**OXFORDSHIRE COUNTY COUNCIL'S RESPONSE TO CONSULTATION ON THE
FOLLOWING DEVELOPMENT PROPOSAL**

Application no: 14/01740/REM

Proposal: Reserved Matters to Outline application (10/01642/OUT) - Erection of 103 dwellings with associated car parking, infrastructure, landscaping and other works

Location: Heyford Park Camp, Upper Heyford

HEYFORD PARK, PARCEL B2B/B5A/B5B - **GARAGE TYPE G2**

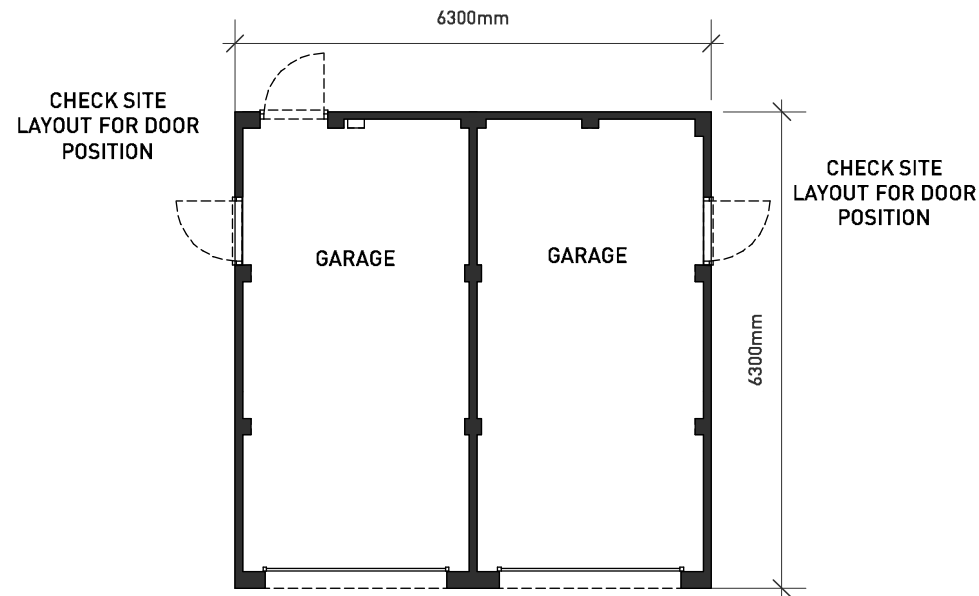
Garage dimensions set out in OCC parking standards for new residential development require internal dimensions of 6.0m length and 3.0m width. The required internal width of a double garage would need to be 6.0m. The following garage types do not meet these internal dimensions:

- G1, drawing no.B0285_91-G1, internal length is less than 6.0m;
- G2A, drawing no.B0285_91-G2A, internal width is less than 3.0m;
- G2, drawing no.B0285_52A-G2, internal widths are less than 3.0m;
- G2C, drawing no.B0285_52A-G2C, internal width of double garage is less than 6.0m.

This will have to be rectified.
